Our ref: HA/2022/124242/01-L01
Your ref: LU/132/22/PD
Date: 27 June 2022

NOTIFICATION FOR PRIOR APPROVAL UNDER SCHEDULE 2 PART 3 CLASS MA FOR THE CHANGE OF USE FROM COMMERCIAL, BUSINESS AND SERVICE (USE CLASS E) TO 2 NO. 1 BEDROOM GROUND FLOOR APARTMENTS (USE CLASS C3).

RIVERBREEZE RESTAURANT 56-57 PIER ROAD LITTLEHAMPTON BN17 5LP

PROPOSED GROUND FLOOR PLAN 1:50

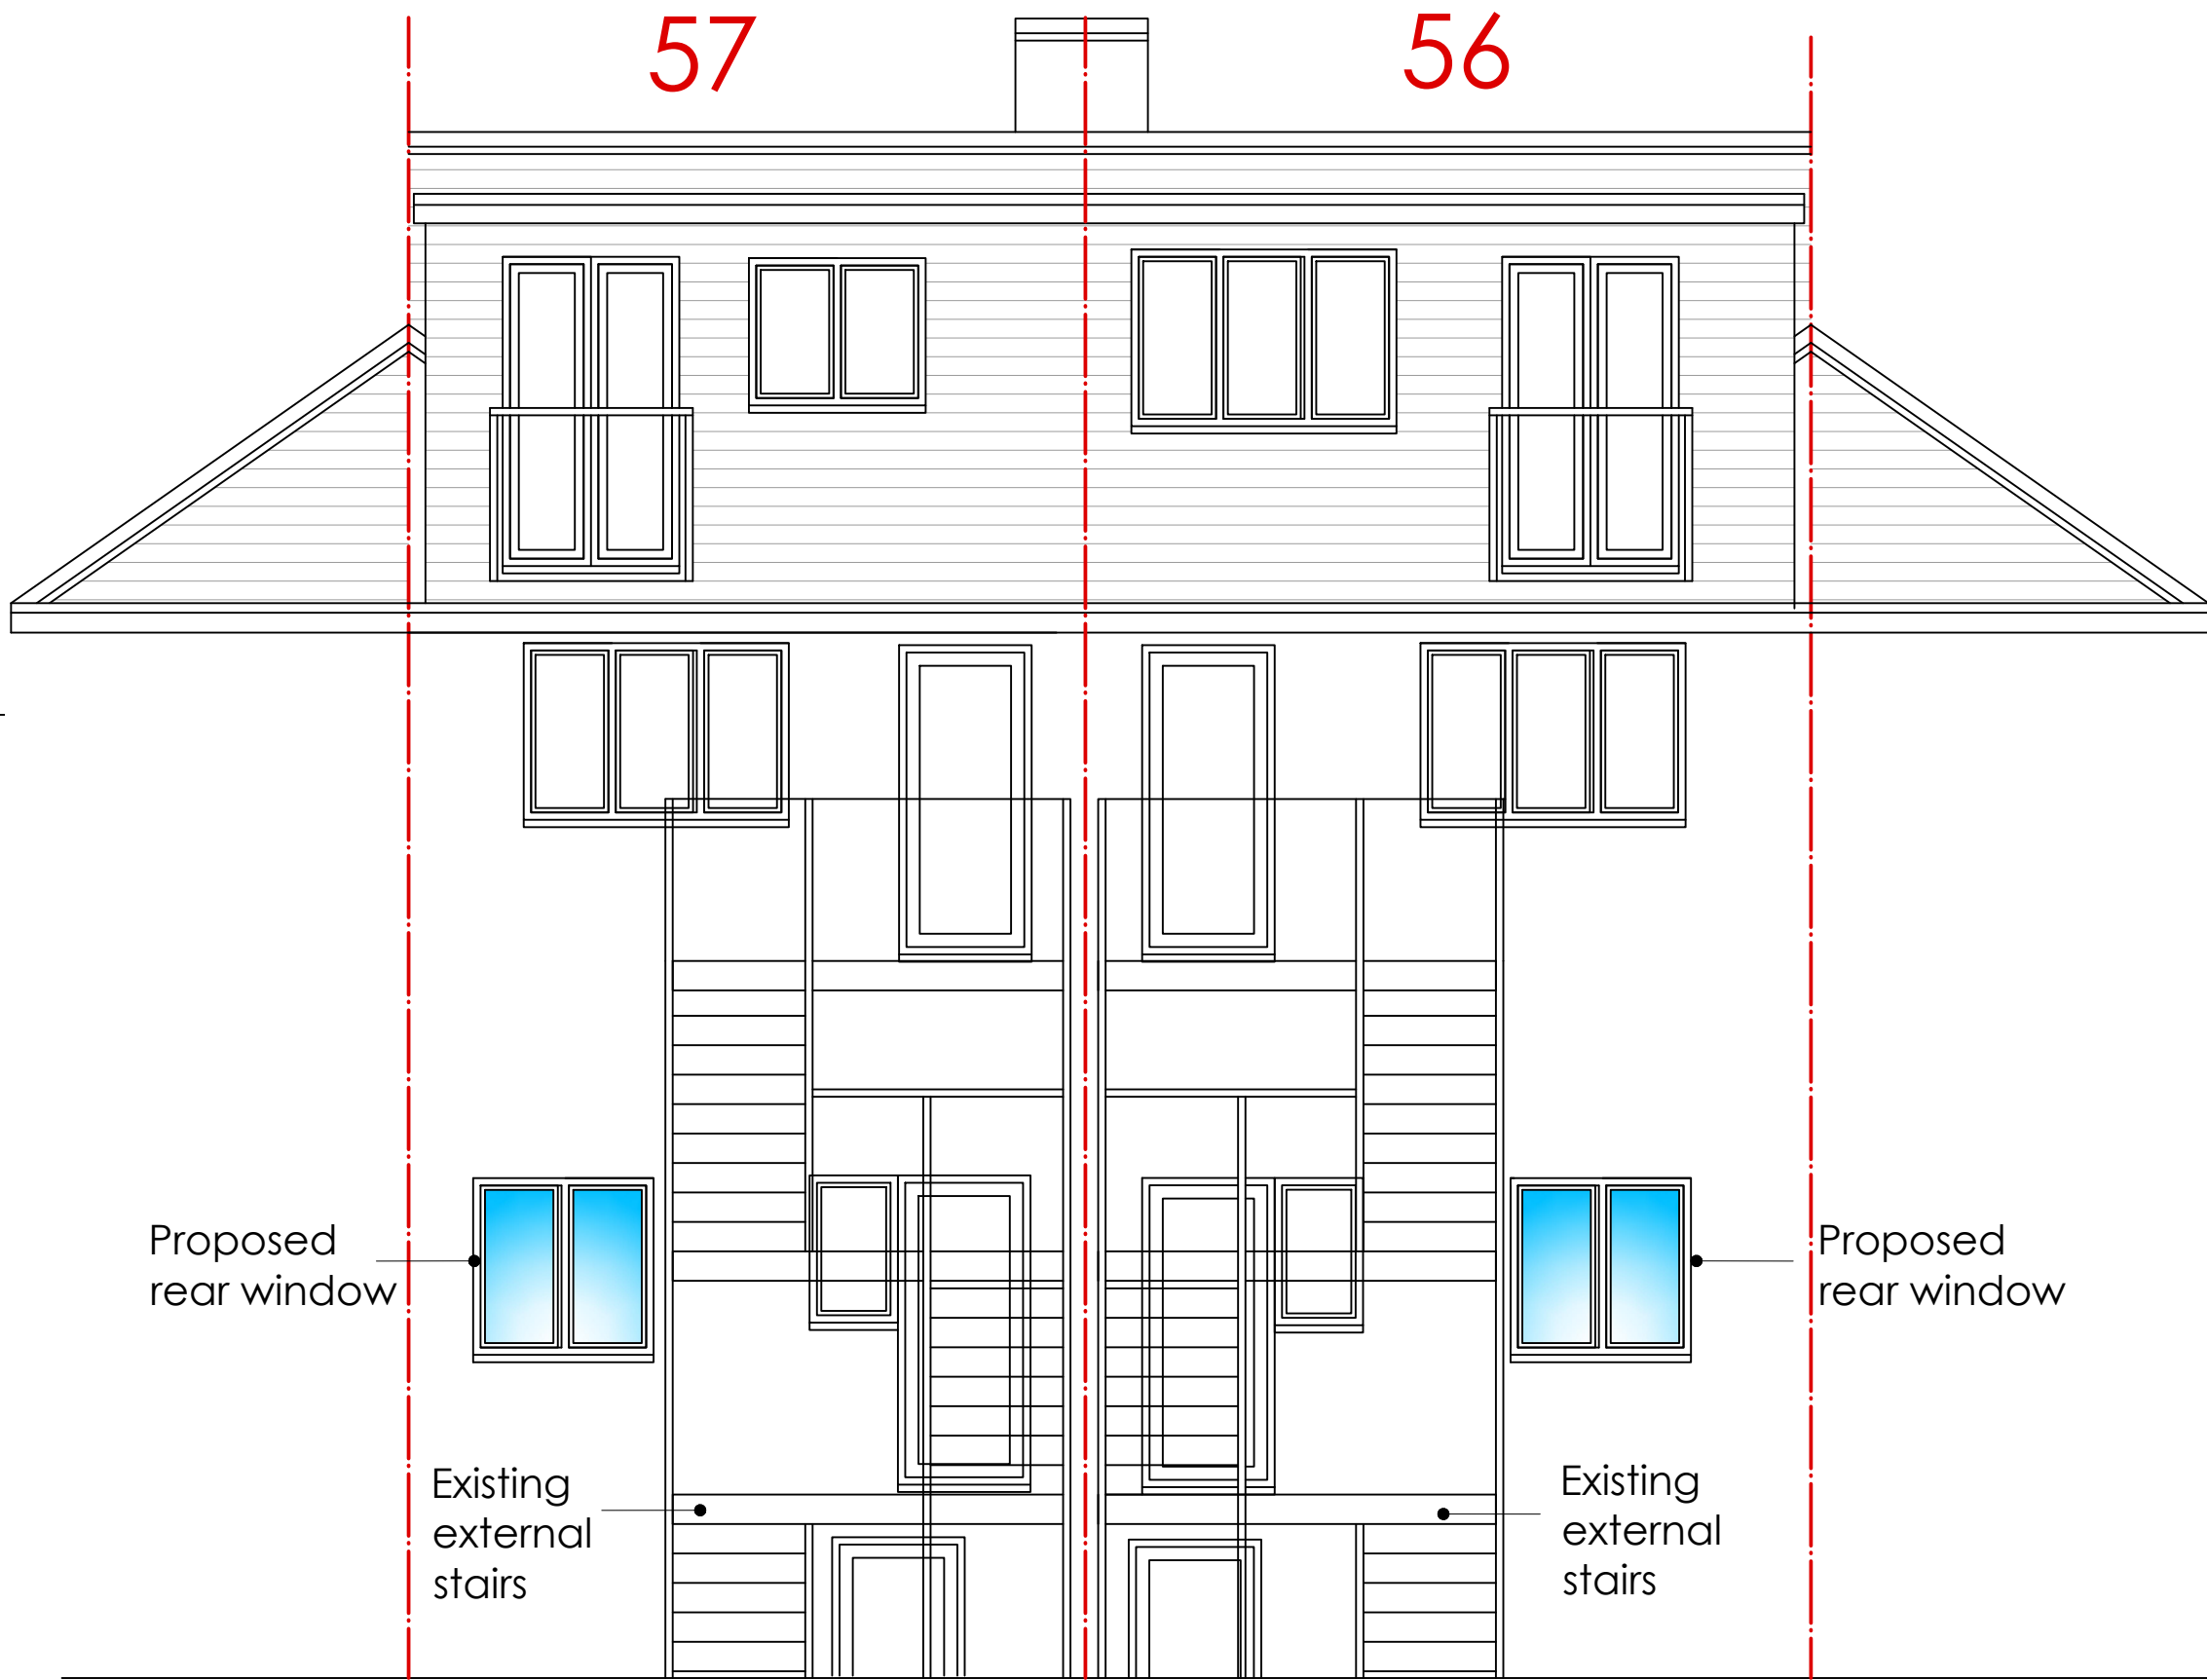
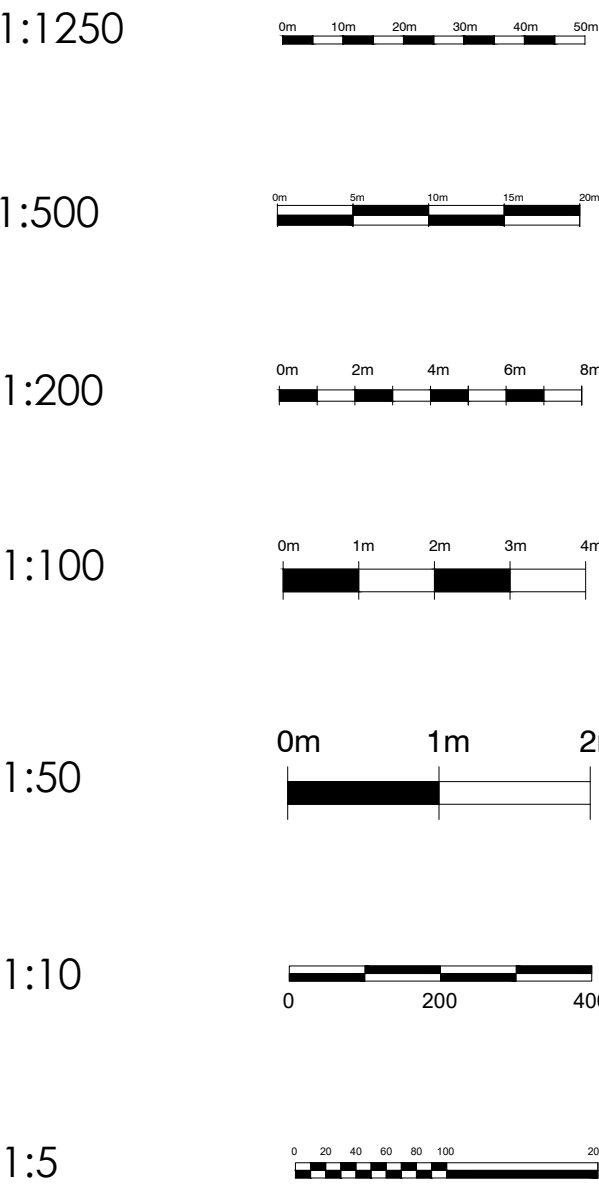
Although the applicant has proposed raising the floor level of the ground floor by 300mm to 4.3mAOD, from our modelling it can be seen that the current Climate Change Allowances would put the flood levels above this height. Therefore a more detailed FRA where the applicant considers flood levels and the mitigation of any impacts would be required.

To overcome our objection, the applicant should submit a revised FRA and amended plans which addresses the points highlighted above.
